East Anglia One North (EA1N) and East Anglia Two  
(EA2) Offshore Wind Farms

Planning Inspectorate Reference: EA1N – EN010077 &  
EA2 – EN010078

Deadline 4 - 13 January 2021

East Suffolk Council's Response to Additional  
Information Submitted by Applicants at Deadline 3

| Important Hedgerows and Tree Preservation Order Plan Sheet Number: Sheet 2 of 12 | | | Rev | 5 | British National Grid OSGB36 |

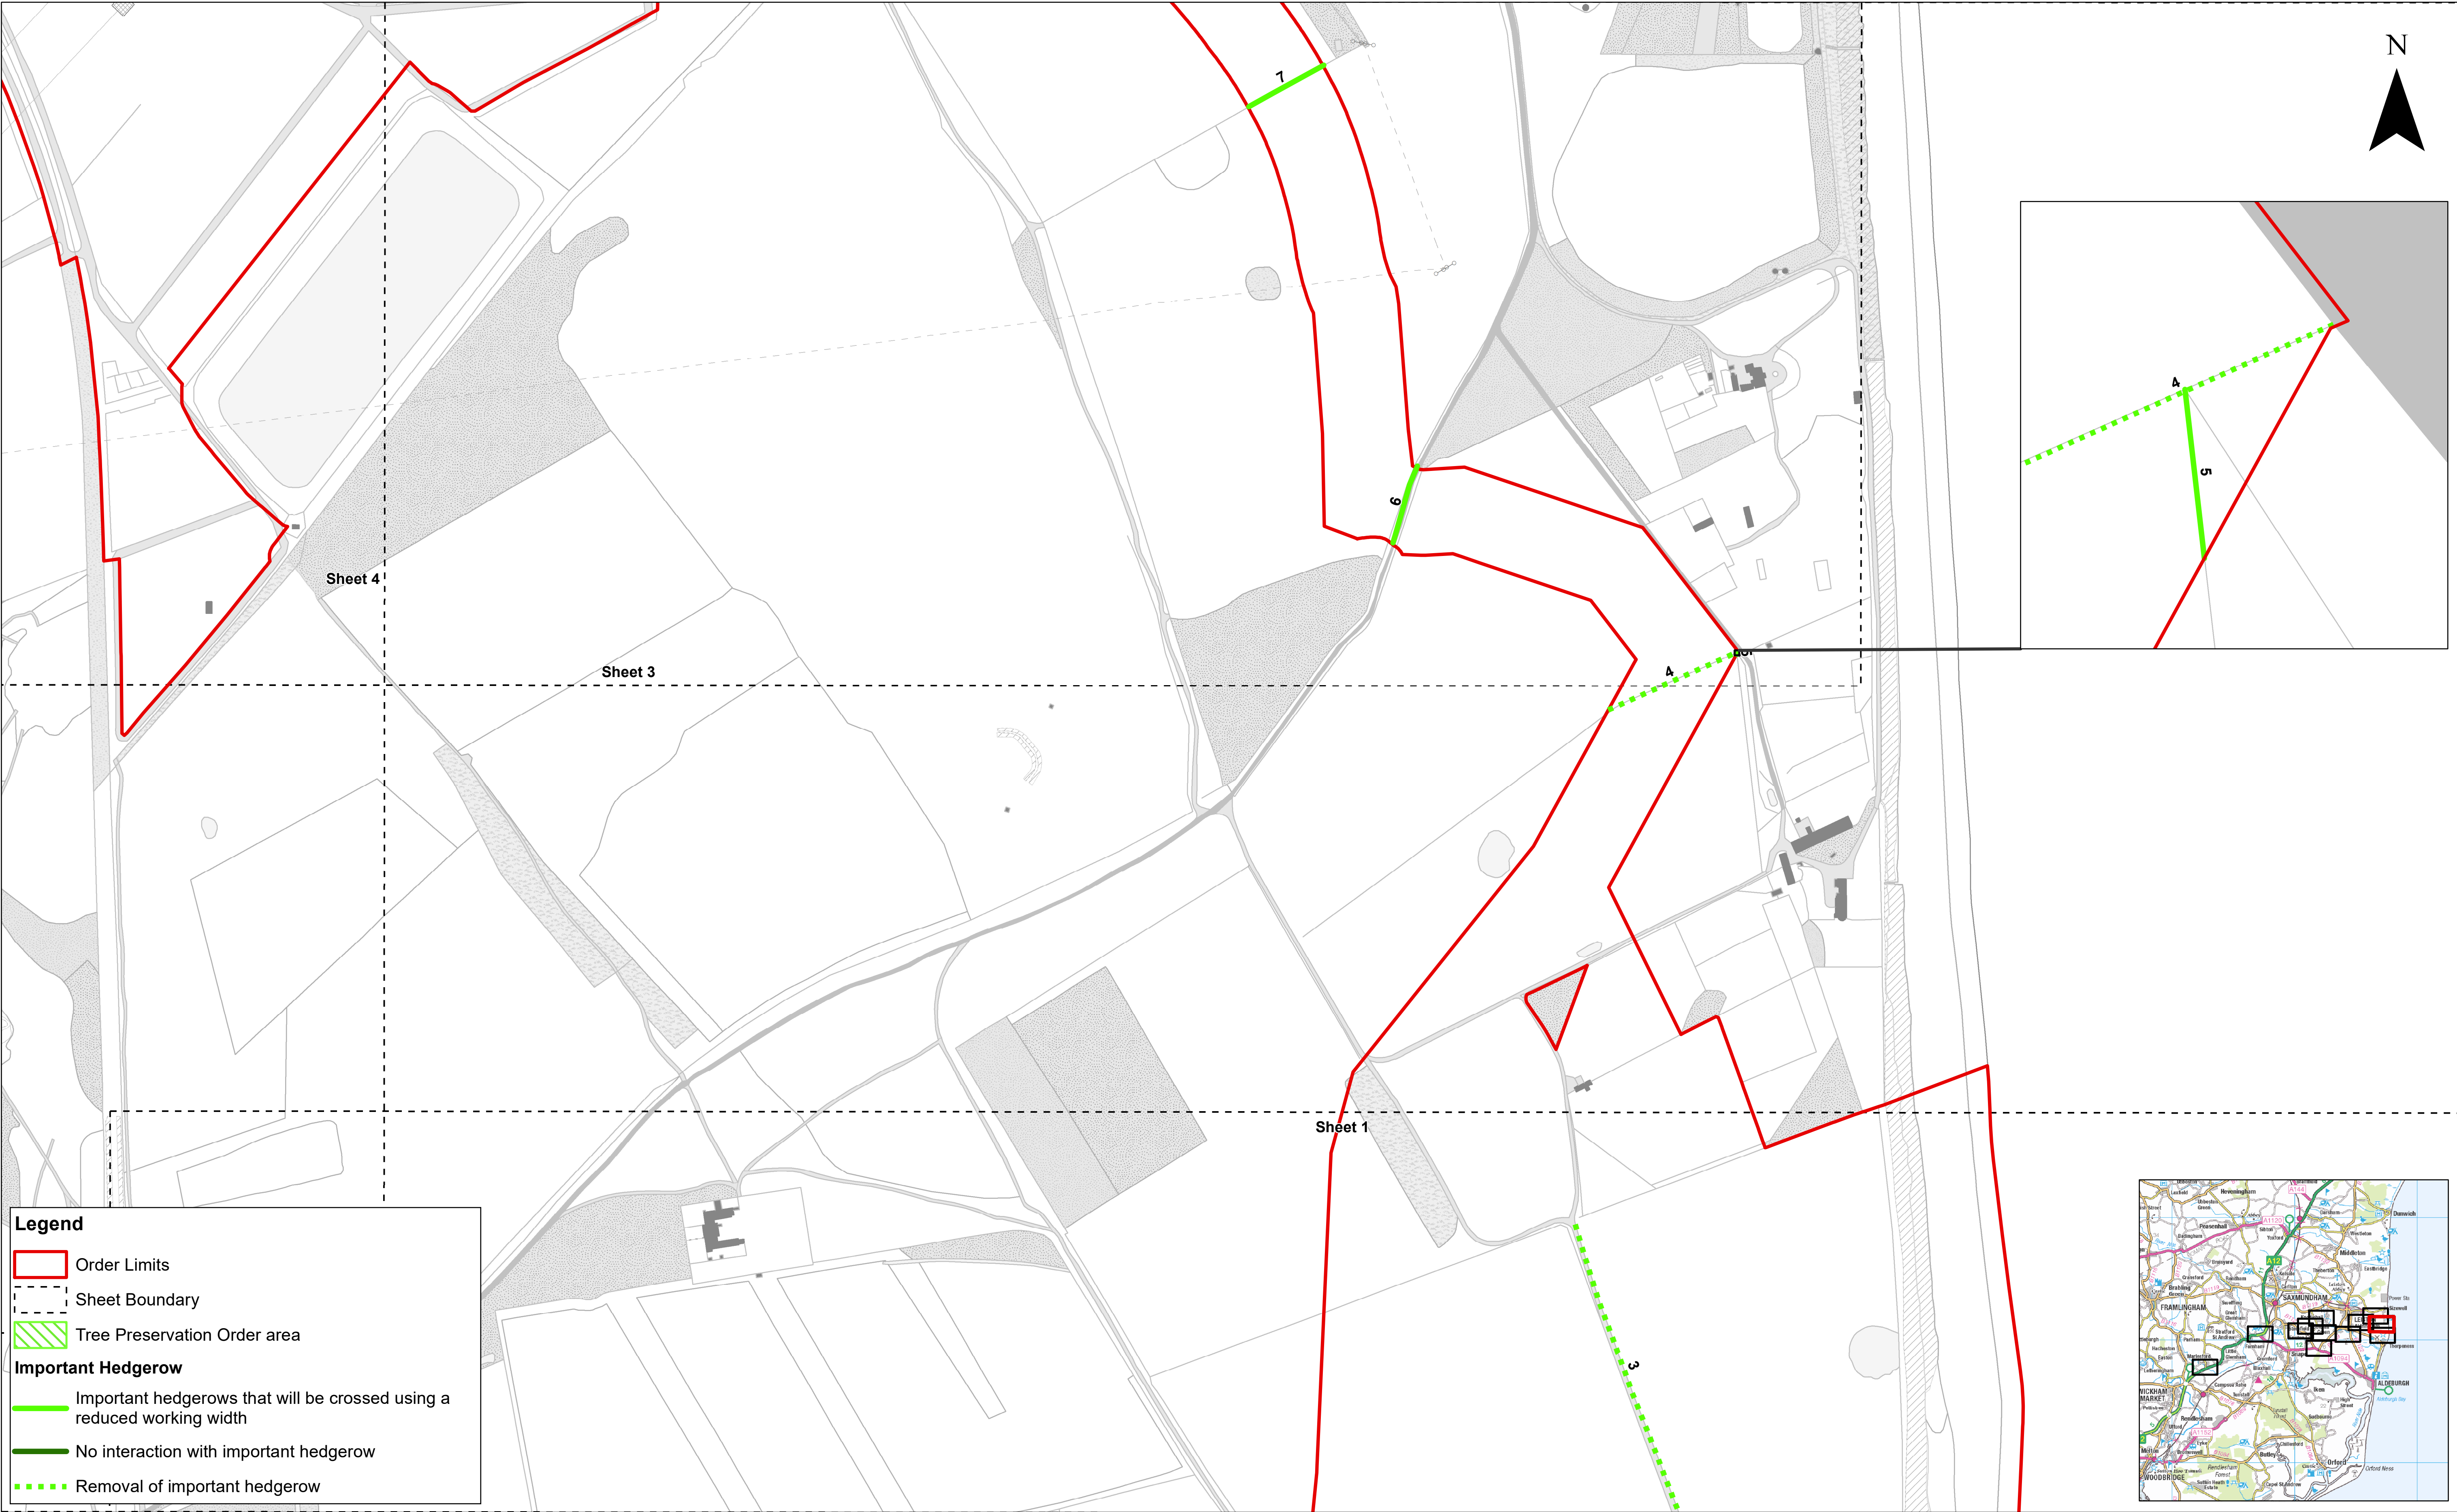
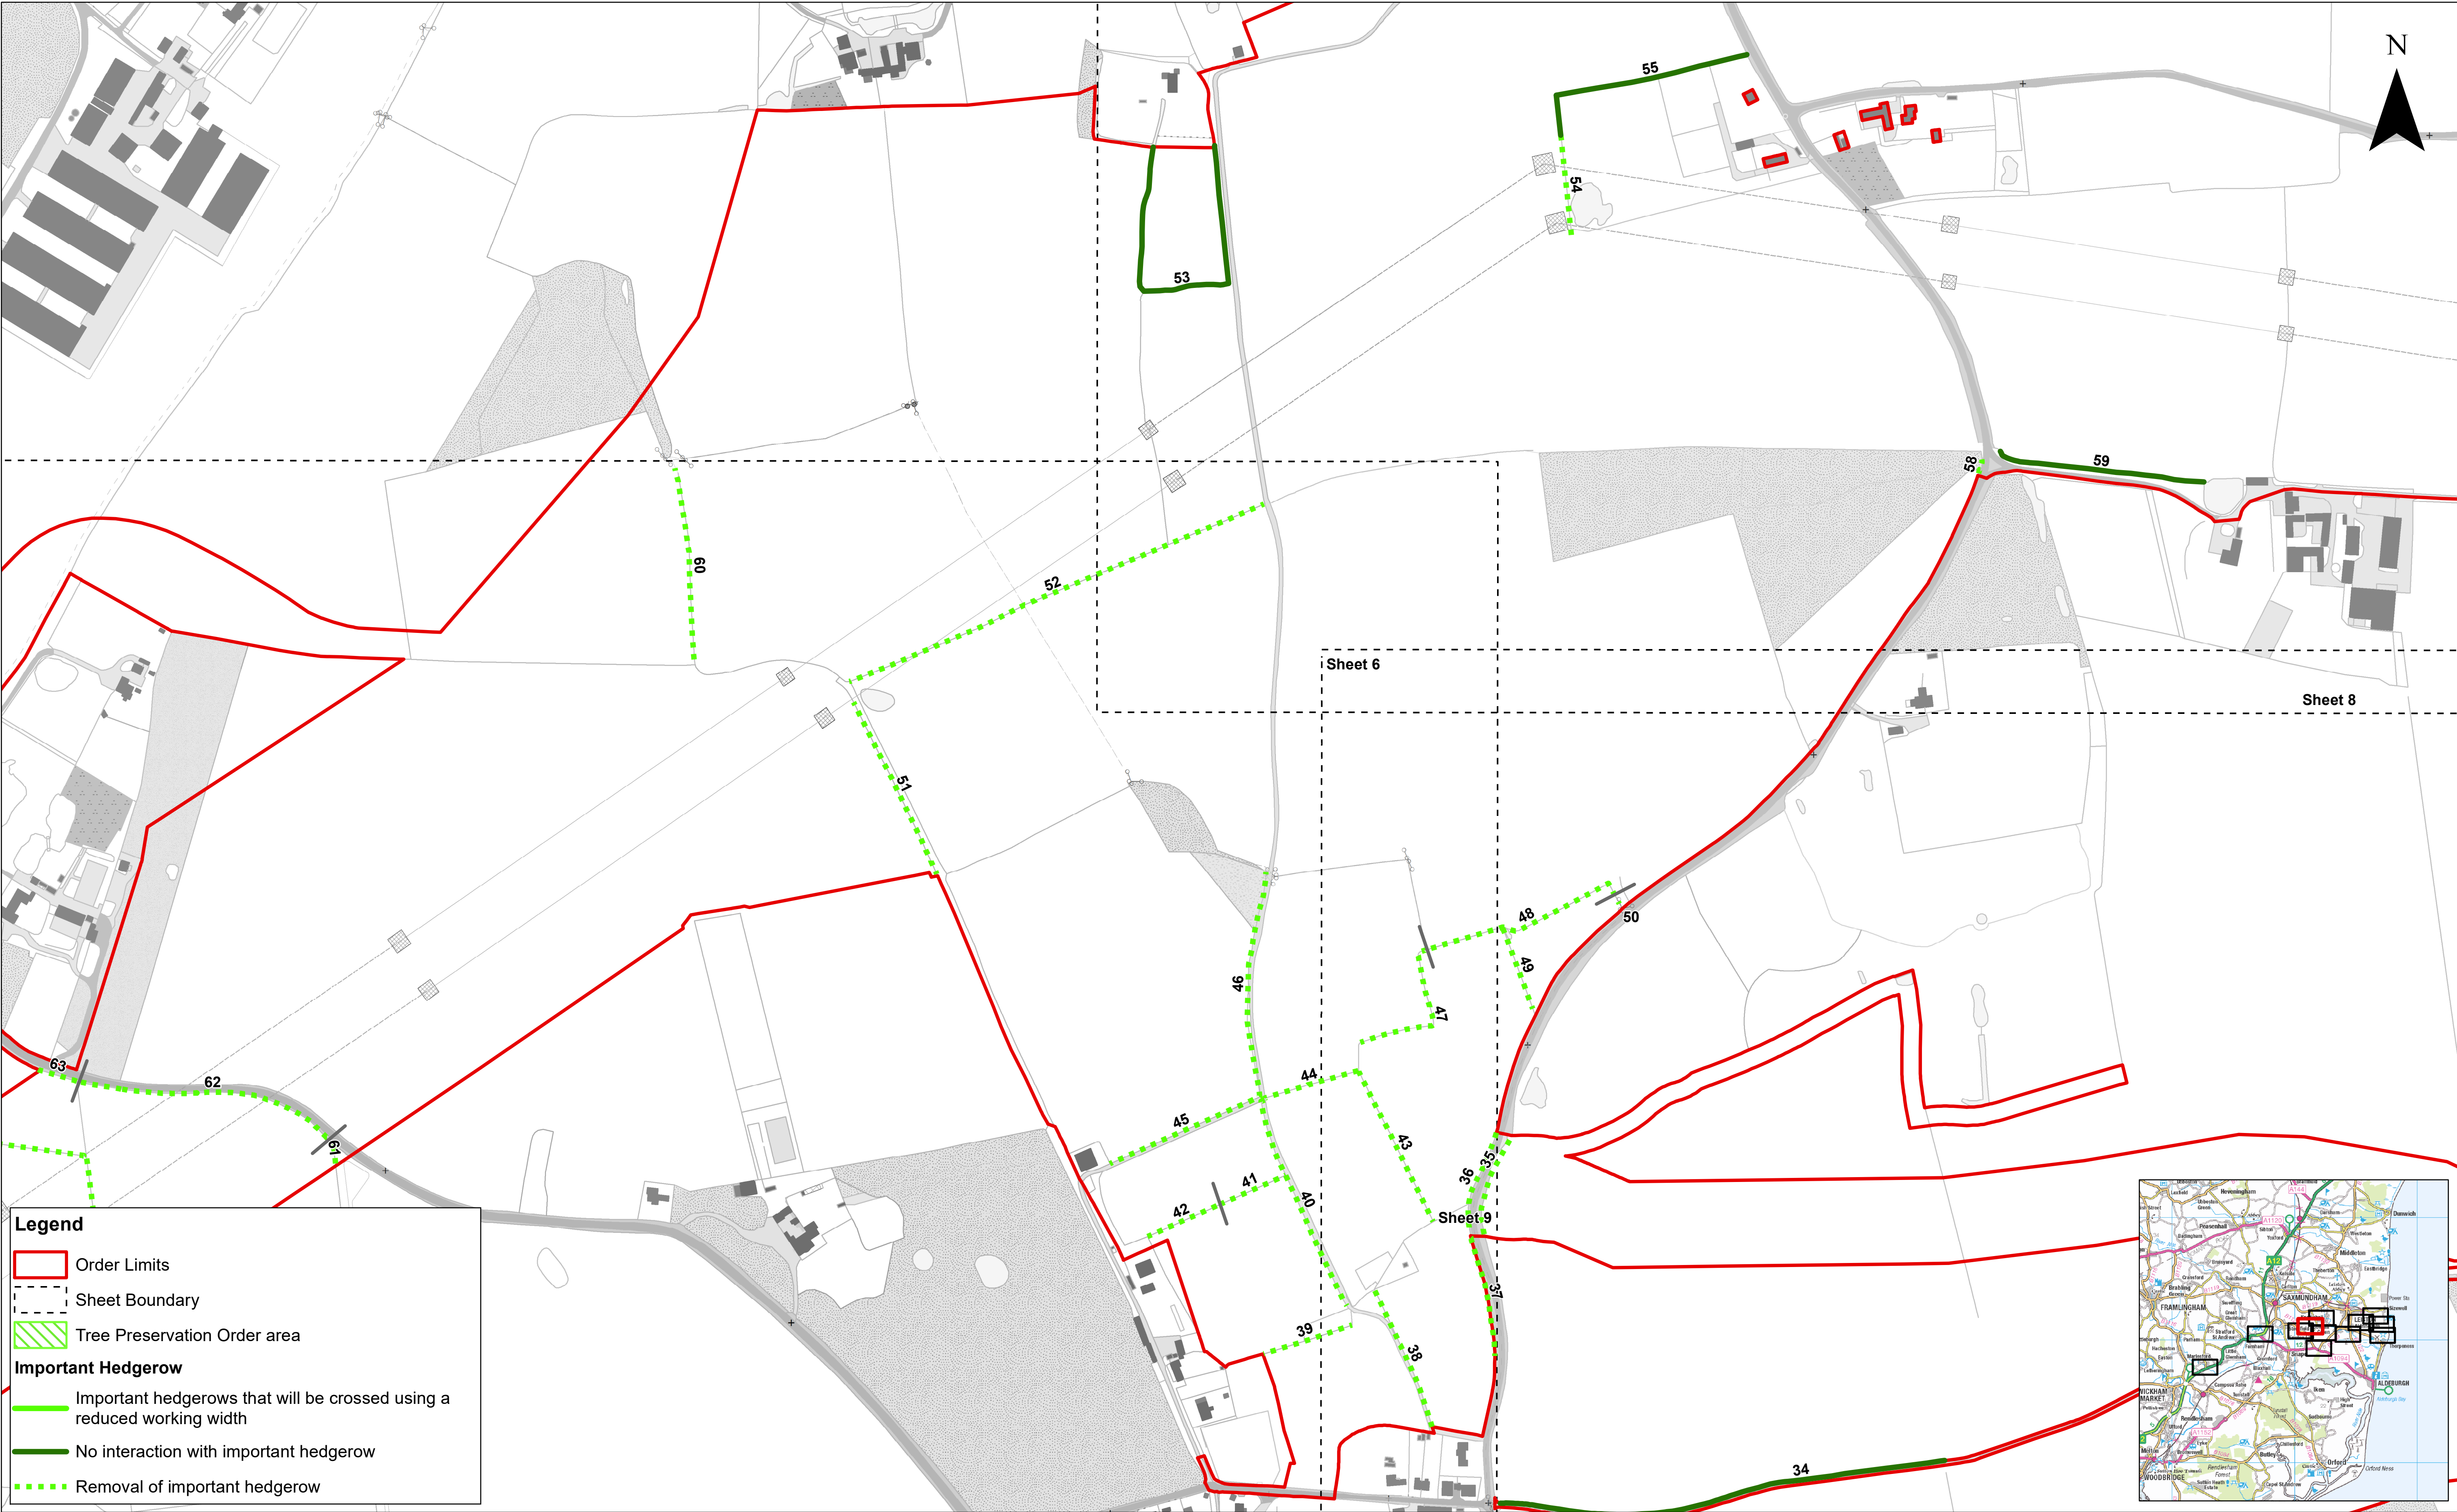
<b>Important Hedgerows and Tree Preservation Order Plan (REP3-010)</b>		
		Hedgerows 1 and 2 are identified within the Important Hedgerows and Tree Preservation Order Plan as being crossed with a reduced width but are identified within Schedule 11 as being removed. Clarification on this is required.
<b>Draft Development Consent Orders (dDCOs) (EA1N and EA2 – REP3-011)</b>
